February 23, 2017

**Elan-Santa Monica Place Senior Assisted Living/Memory Care  
6901 San Vicente Ave. NE  
Request Permanent C.O. - Accepted  
Engineer's Stamp dated: 10-16-15 (D18D054B)  
Certification dated: 2-10-17**

**Re: Elan-Santa Monica Place Senior Assisted Living/Memory Care  
6901 San Vicente Ave. NE  
Request for Temporary 60-Day CO – Accepted  
Engineer's Stamp dated: 10-16-15 (D18D054B)  
Certification dated: 2-10-17**

**RE: Santa Monica Place (Senior Assisted Living/Memory Care)  
East End of Tract 3  
Grading and Drainage Plan  
Engineer's Stamp Date 10-16-2015 (File: D18D054B)**

CG-101

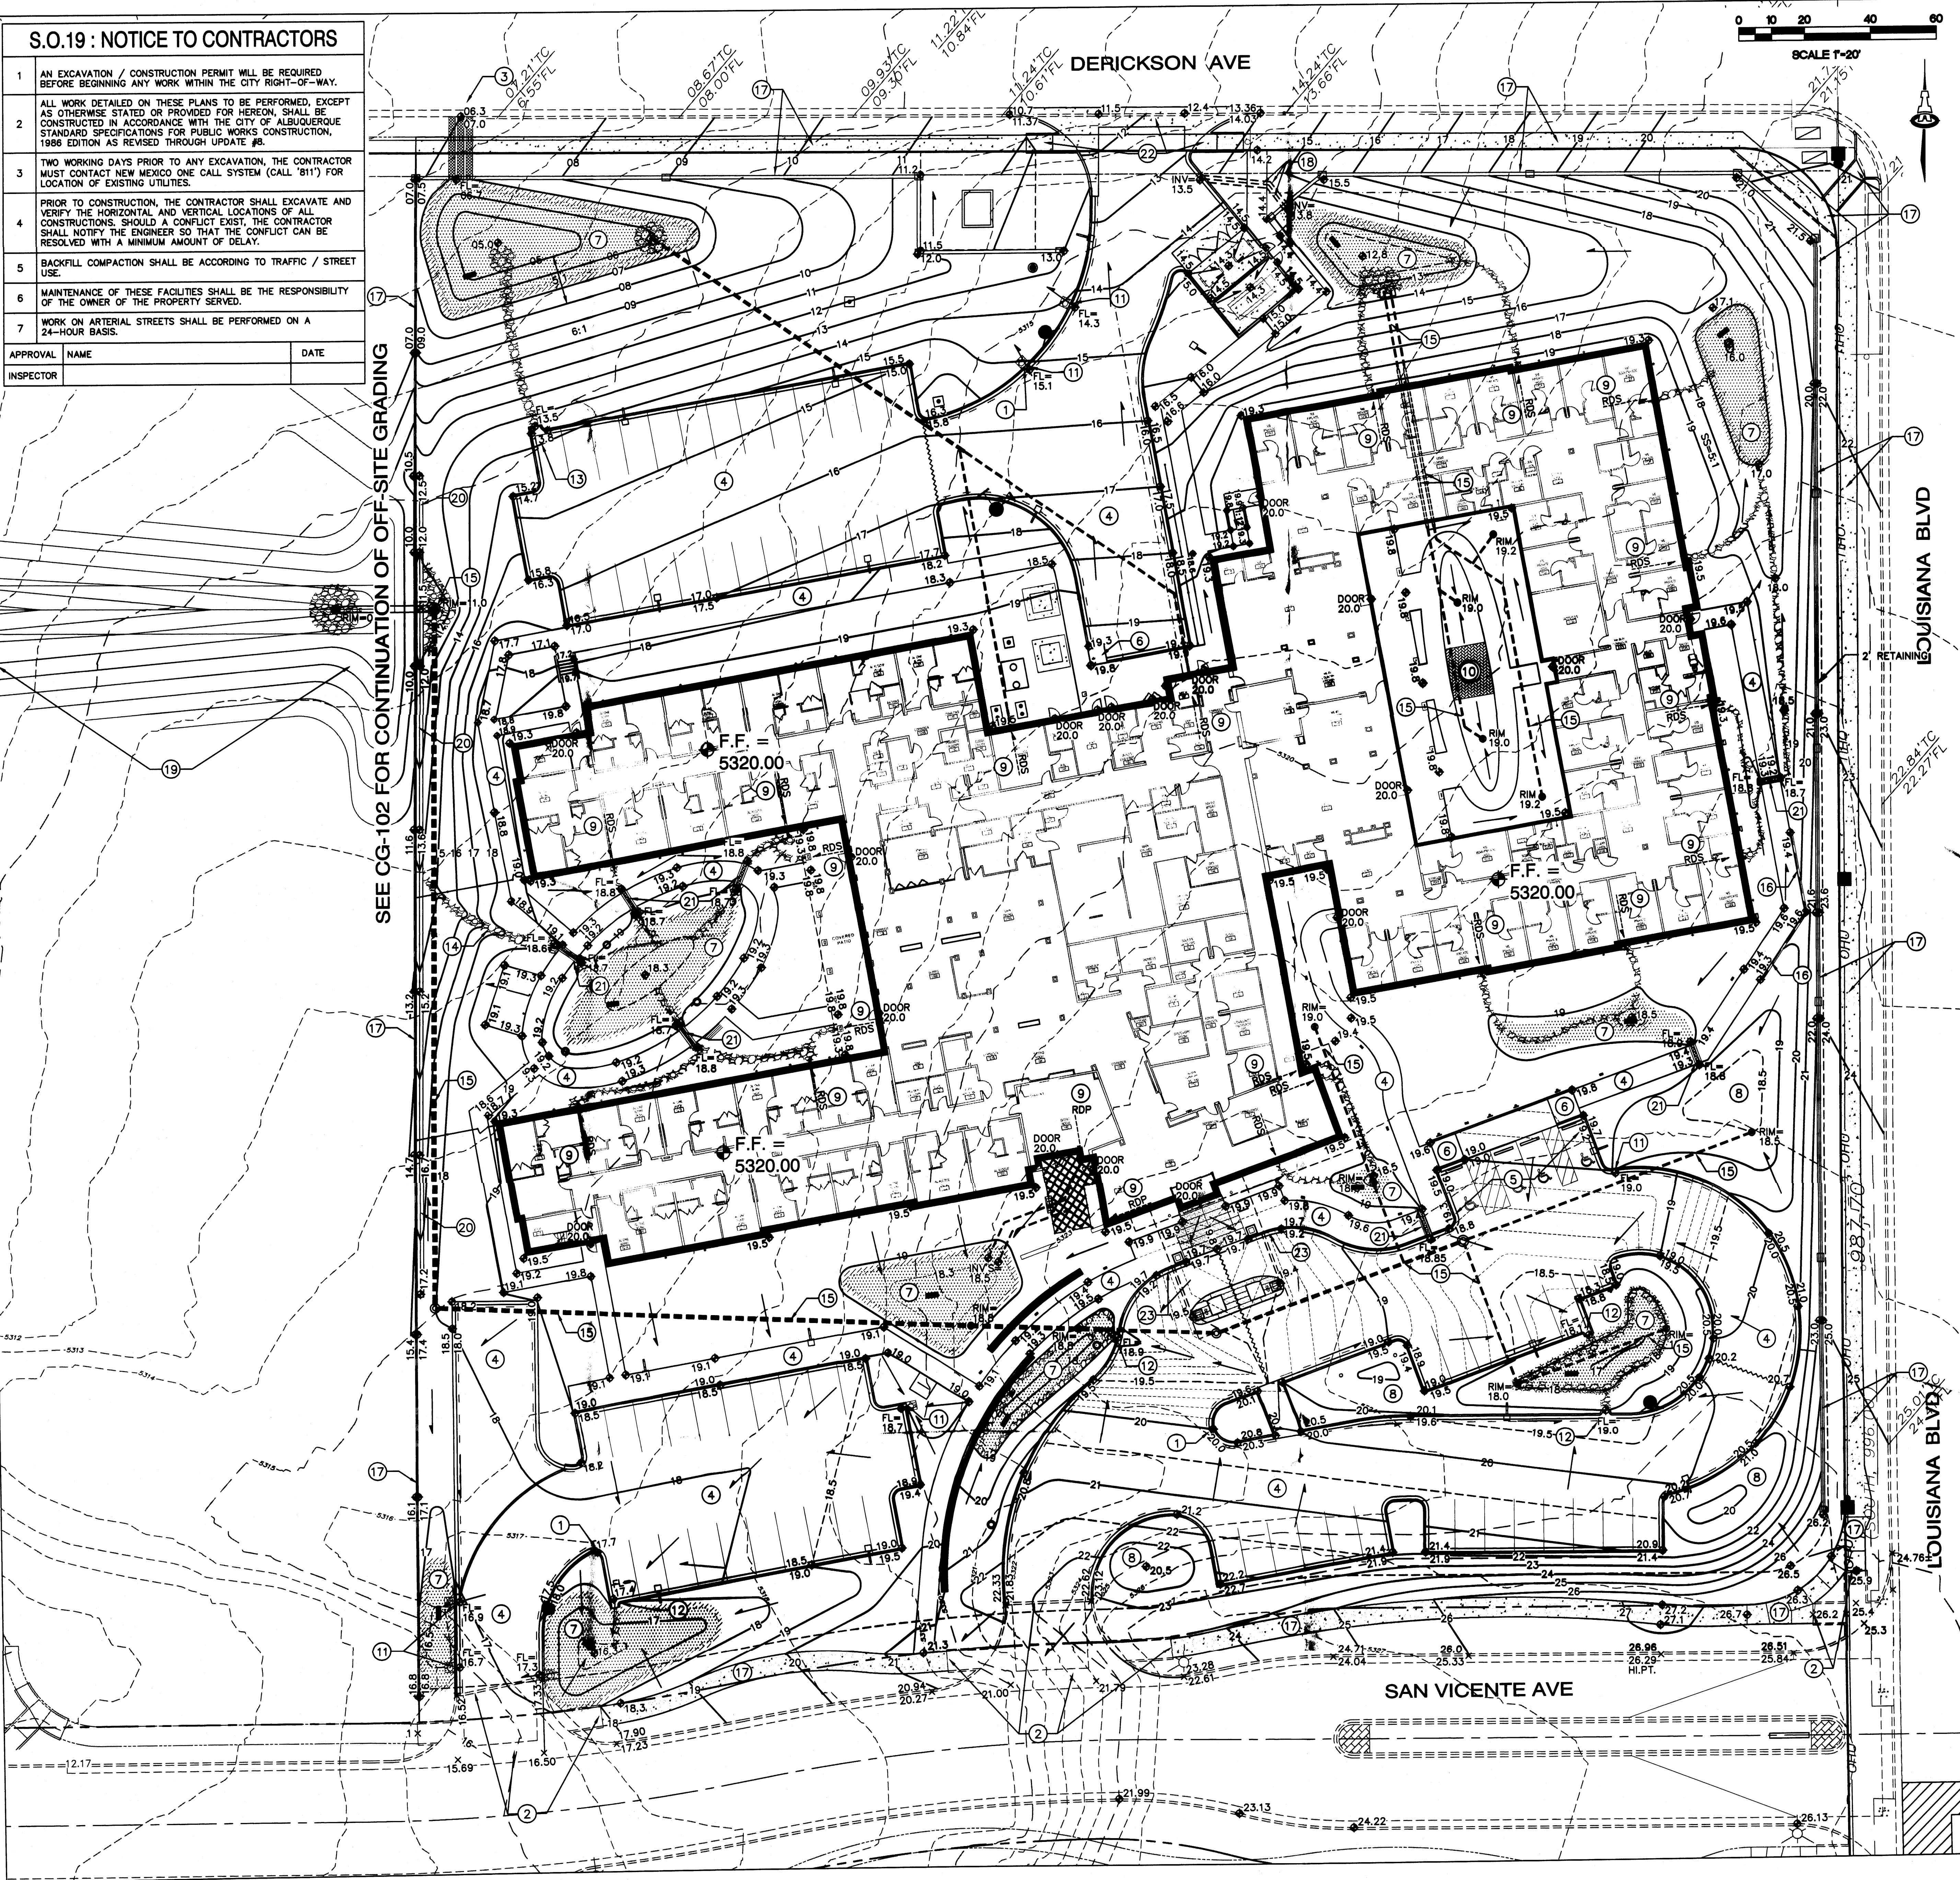
- Specify class IV RCP for the 24" storm drain that will be placed under the retaining wall (or other class only if justified).
- It is assumed that the hatched rectangles shown within the ponds are the percolation pits referenced in Keyed Note 7 on Sheet CG-101.
